Our ref: HA/2011/112354/01-L01
Your ref: FP/177/11/
Date: 21 November 2011

**DEMOLITION OF EXISTING DWELLING TO BE REPLACED BY 3/4 STOREY
DETACHED TOWN HOUSE. AMENDMENT FOLLOWING FP/49/09/
GULL POINT (FORMERLY SEA GIRT) OUTRAM ROAD FELPHAM
WEST SUSSEX PO22 3AN**

Figure 13 - Proposed flood proofing and landscaping

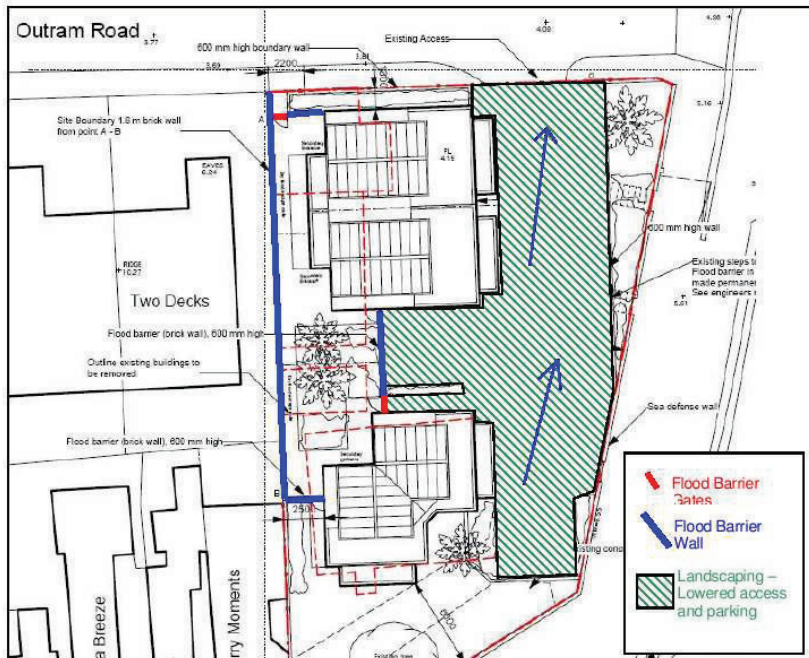
It is possible the request for condition 2 is now not required. Discussions with on site personnel suggest that flood barriers and gates will now not occur. If this is the case this condition should be disregarded.

The development hereby permitted shall not be commenced until such time details of the flood barriers and gates (as referred to at 6.19 and 6.20 of the submitted FRA) has been submitted to, and approved in writing by, the local planning authority.
